ABP-320705-24 (Knockshanvo Wind Farm & 110kV Substation)

VA03.320727 / ABP-317763 (110kV Grid Connection & Subsurface Cabling)

Date: 4th August 2026

We are writing to submit a formal observation directly responding to the planning statements and response to observations submitted by the applicant, FuturEnergy Knockshanvo DAC (prepared by MKO).

Site Layout Keyplan

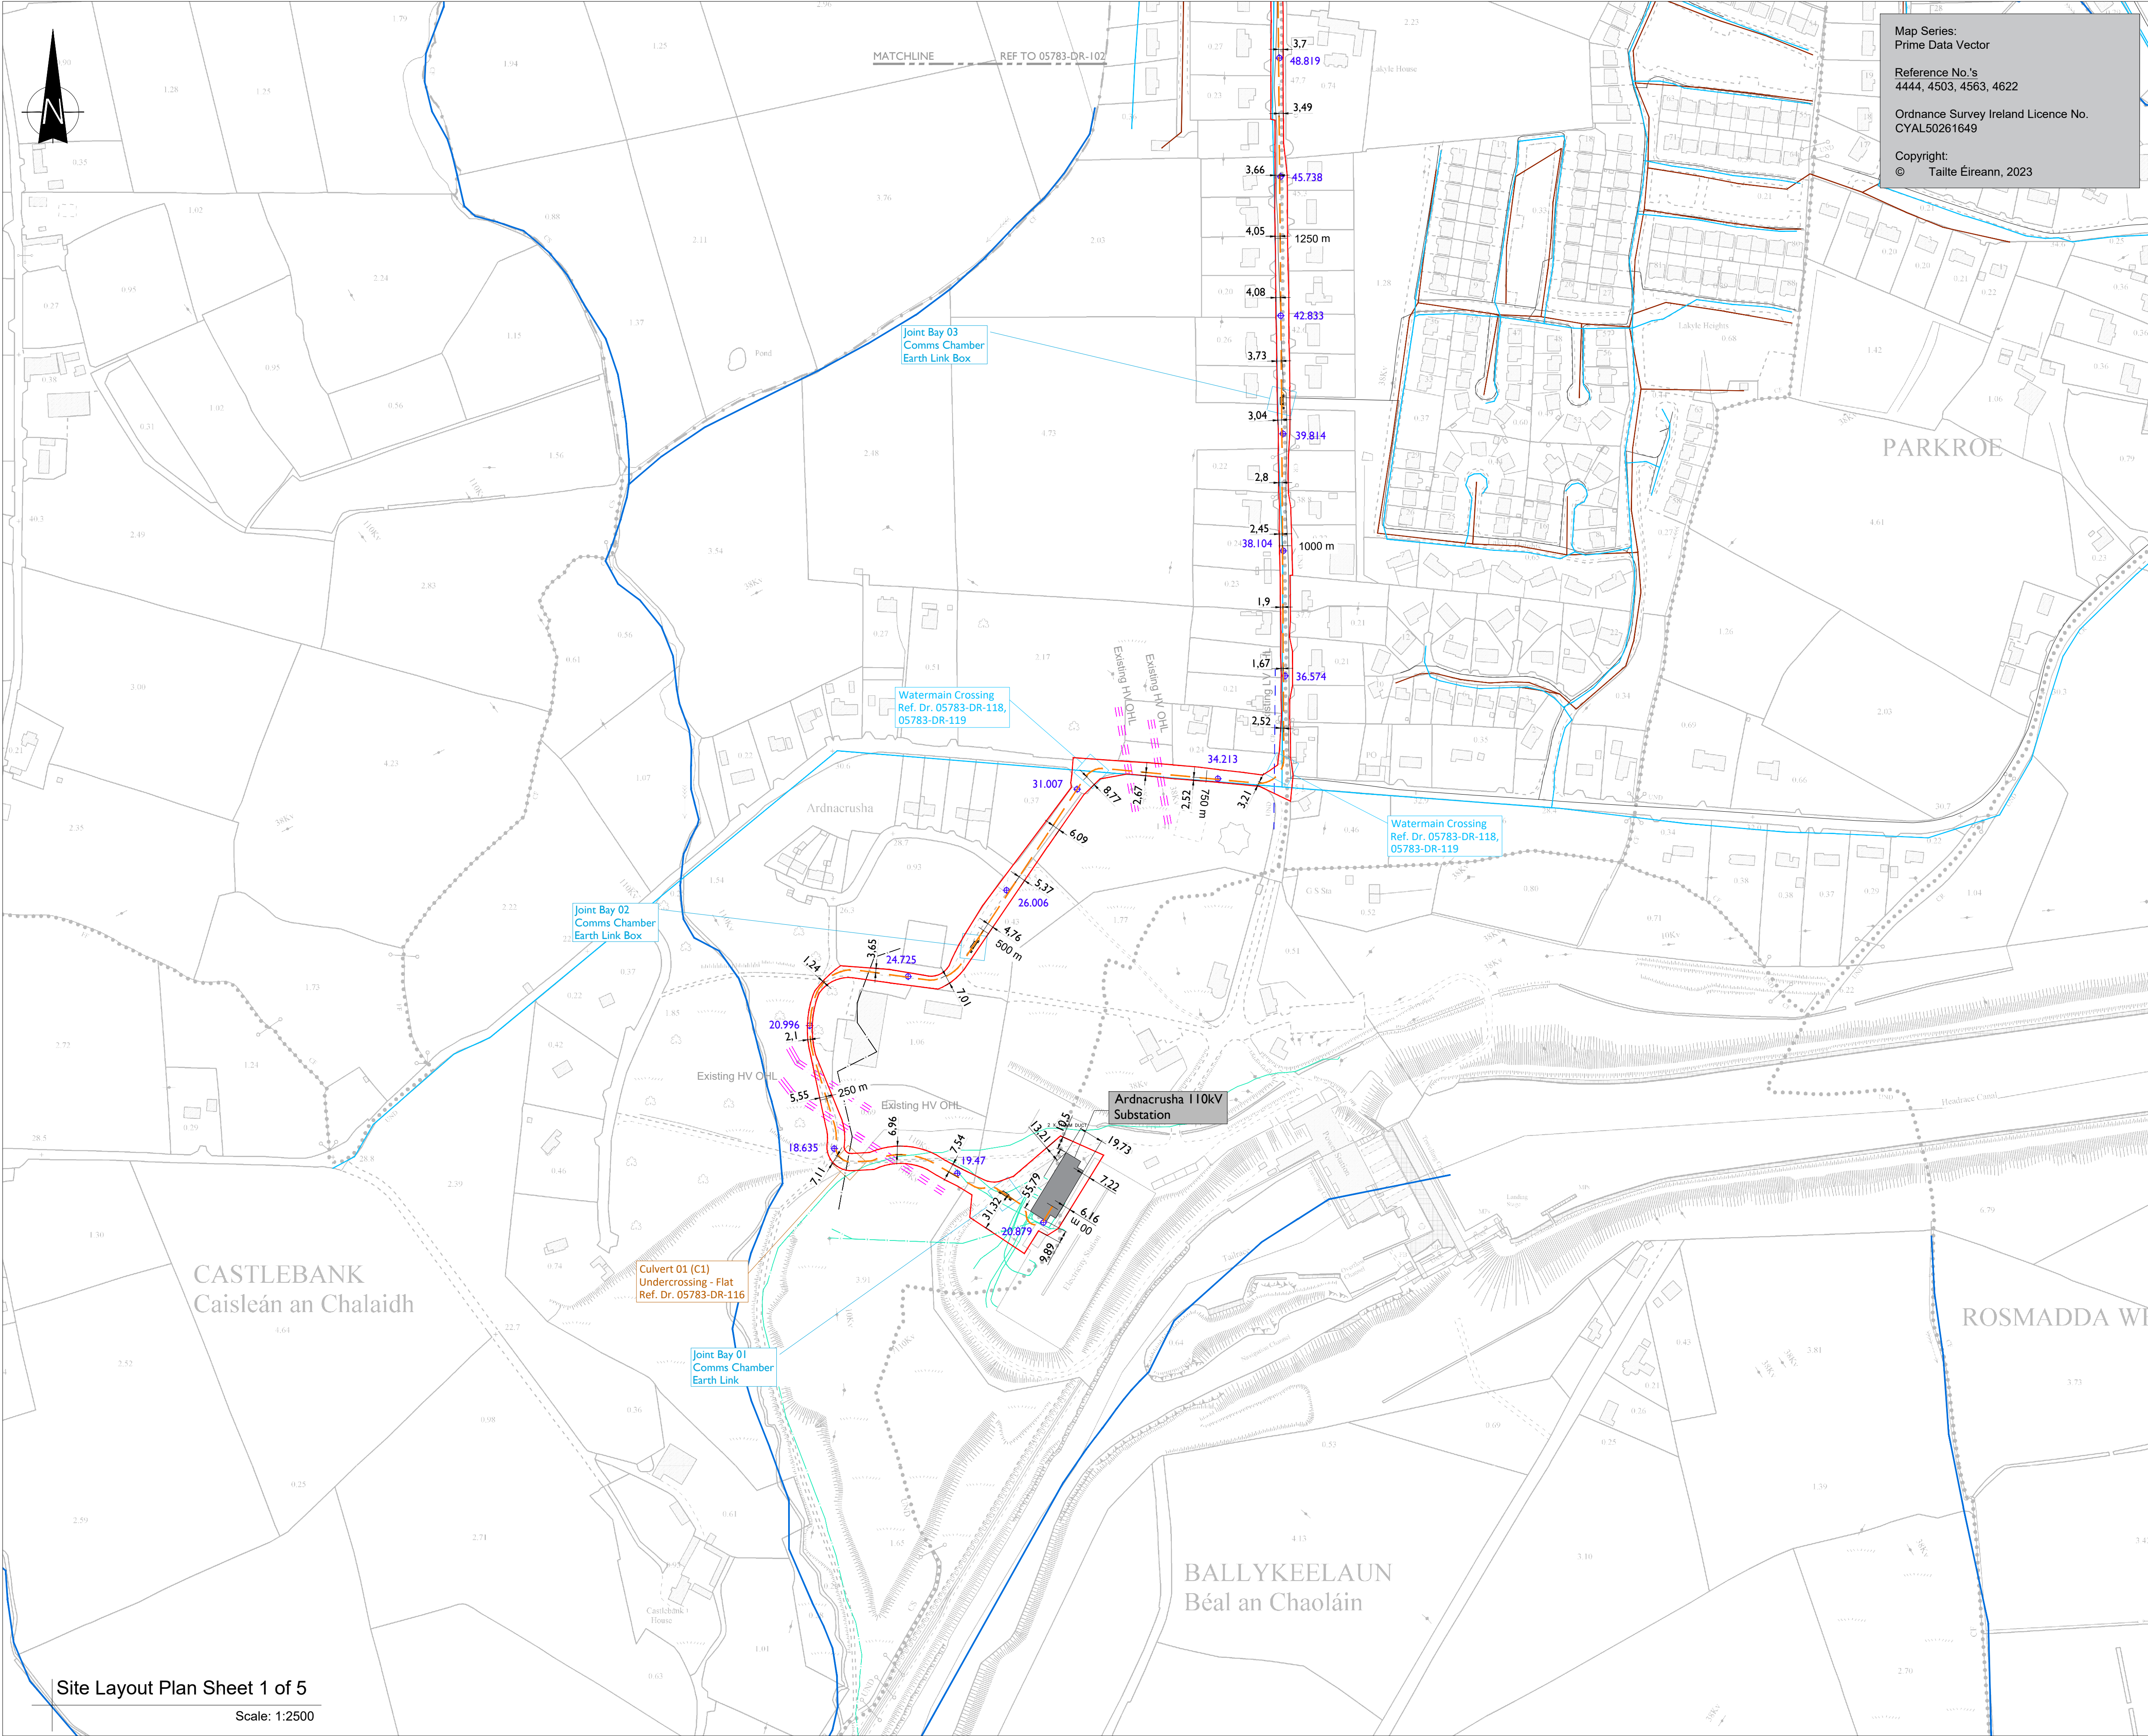
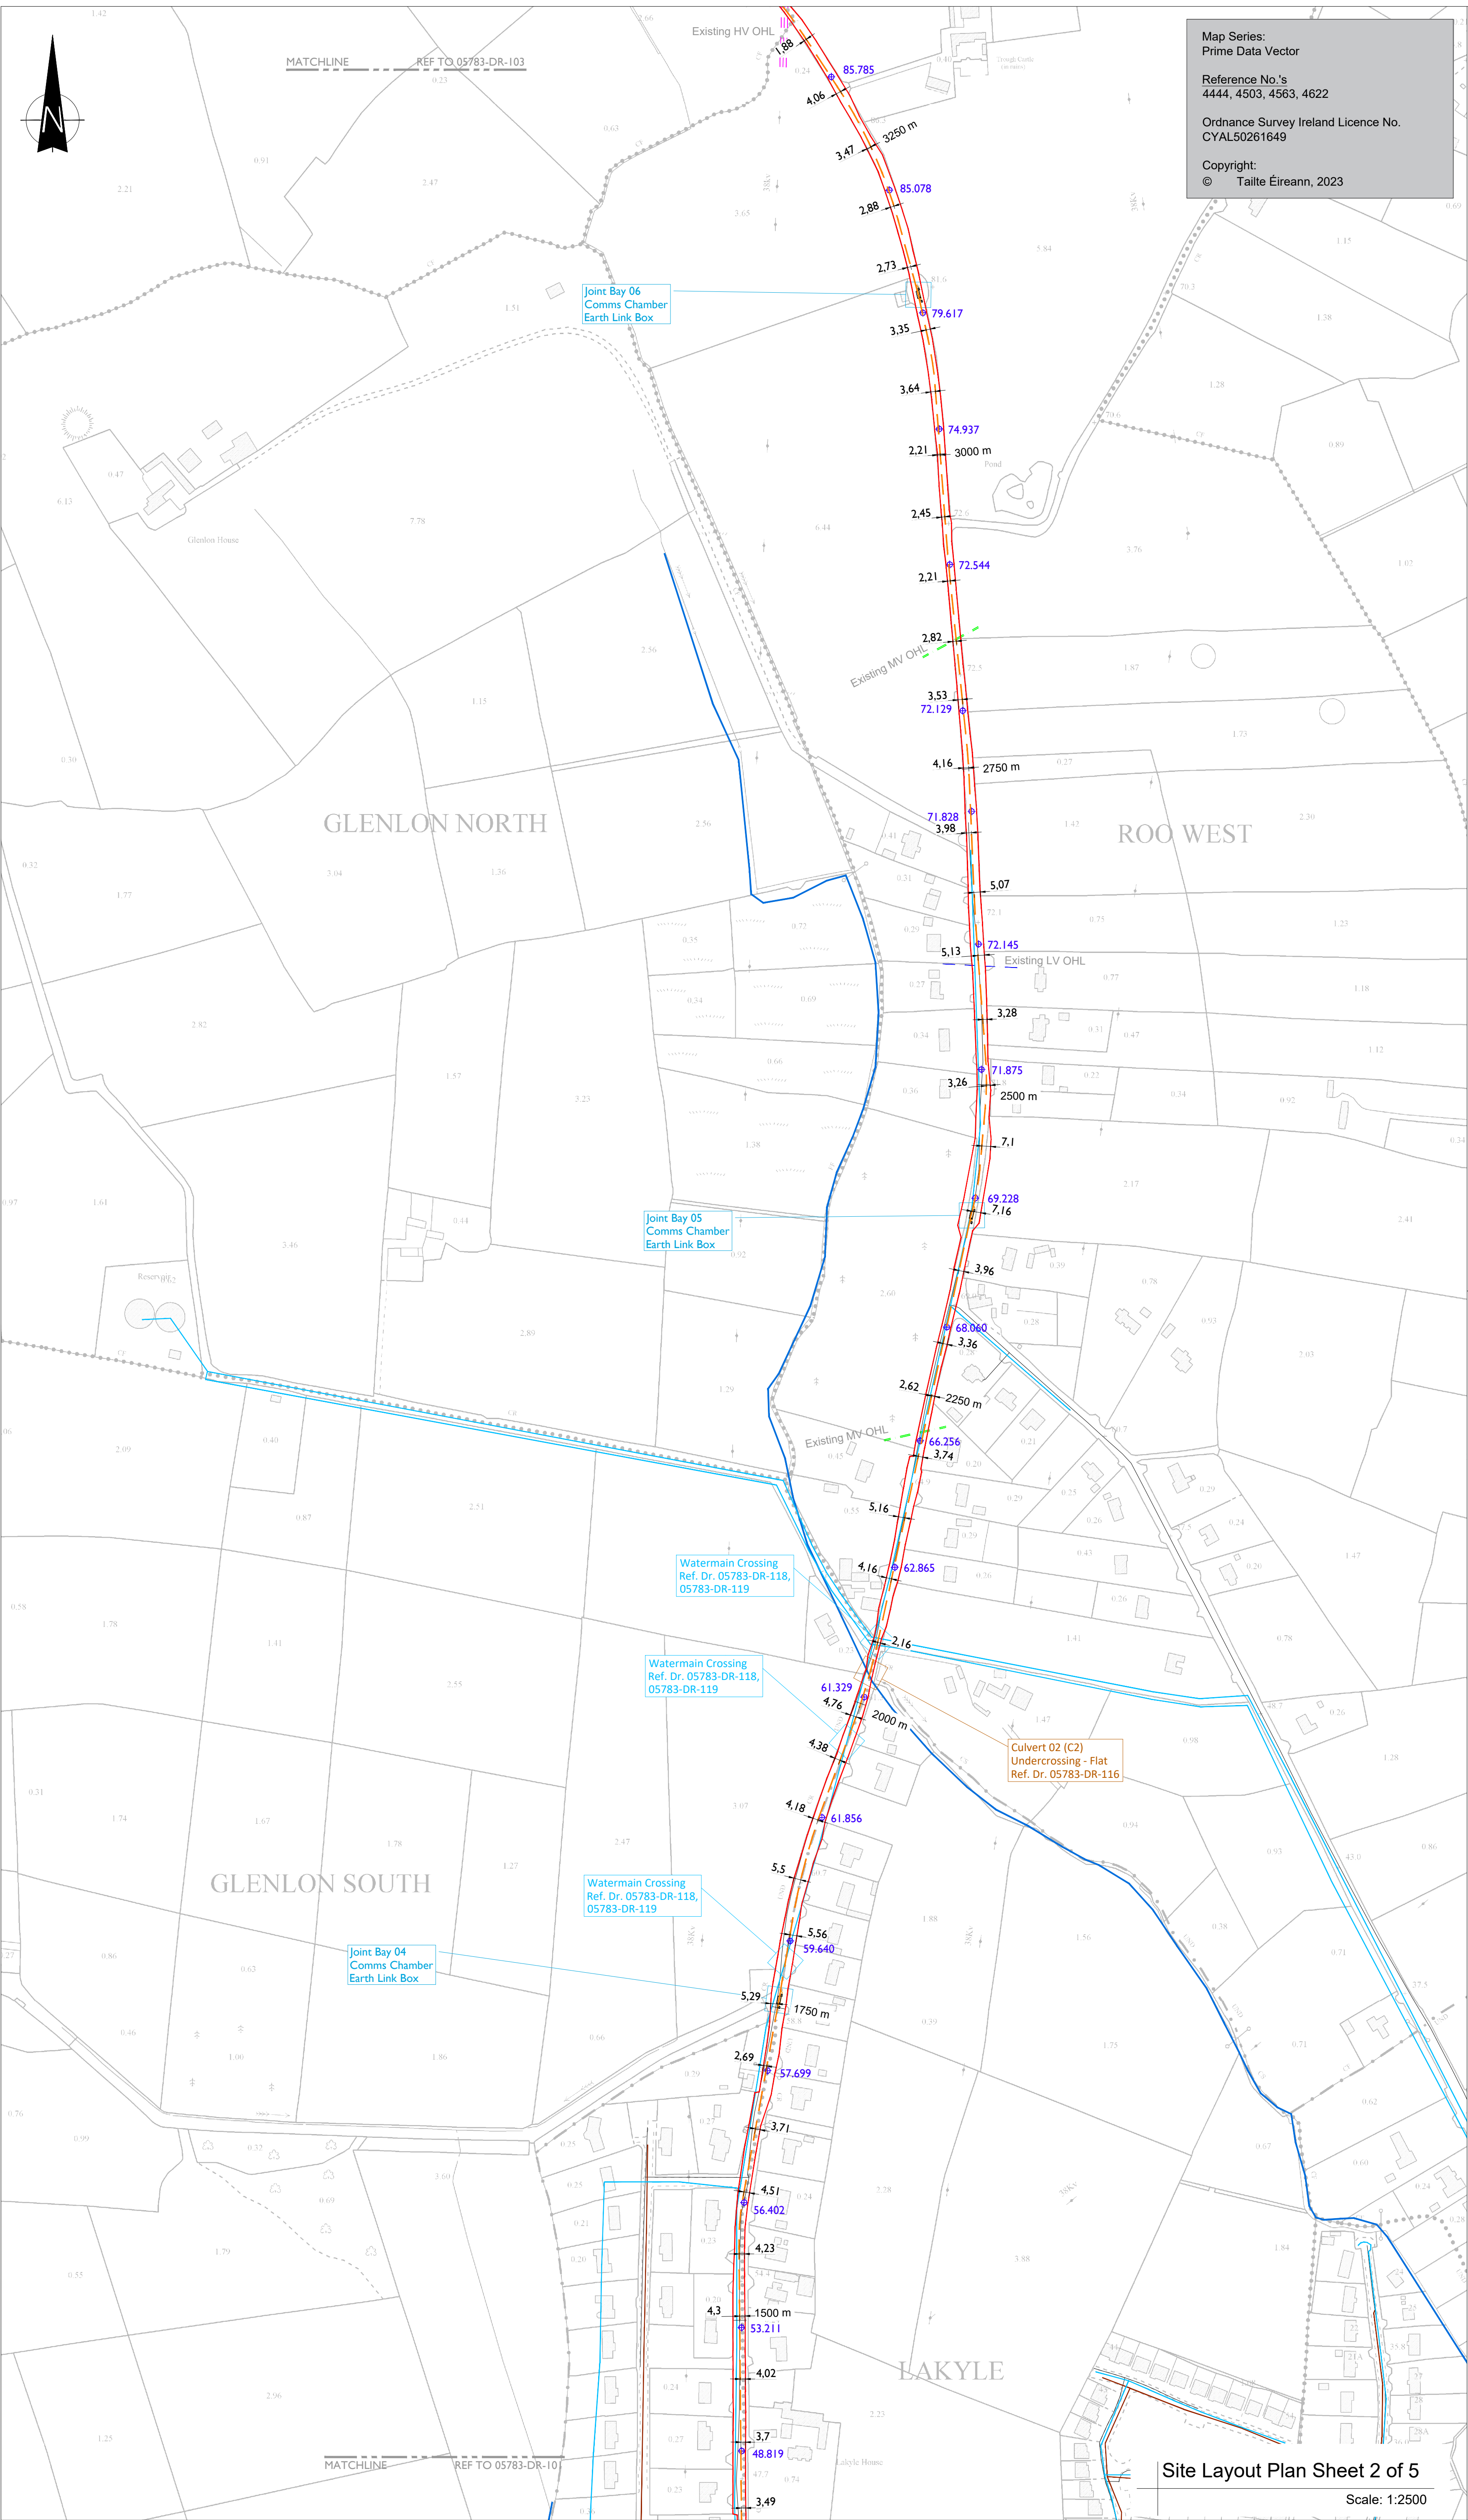
As the side wall of our house forms the direct boundary line flush with Sallybank Road, heavy industrial rock-breaking, excavation, and deep trenching will occur in very close proximity to our home's primary load-bearing walls.

While MKO promises to restore the public road tarmac for Clare County Council, they have provided zero localized structural engineering assessments, zero baseline structural surveys, no vibration monitoring protocols, and no structural indemnity framework to protect our home against catastrophic cracking or subsidence.

Sallybank Road (L3042) is a highly constrained, narrow country lane where two passenger cars cannot consistently pass. Digging an open high-voltage trench while operating heavy industrial plant machinery will physically consume the entire road width outside our gate. The developer has provided no engineering methodology proving how a passable lane can be physically maintained. This layout cuts off our right of way, trapping us inside our property or barring access home, particularly when works are ongoing outside of our property.

Furthermore, as raised in our original submission, we reject the applicant's unfounded assertion that subsurface cable trenching along Sallybank Road (L3042) will progress seamlessly at 100 meters per day to complete in "one month". The applicant's response document provides zero technical or engineering methodology to substantiate this rate of progress along a narrow, constrained country lane. Given that our property sits 3 km along this single-lane corridor, the developer's reliance on generalized post-consent Traffic Management Plans (TMPs) fails to address real-world construction delays, physical road blockades, or how daily residential and emergency access will be physically guaranteed over what will inevitably be a far more prolonged and disruptive timeframe.
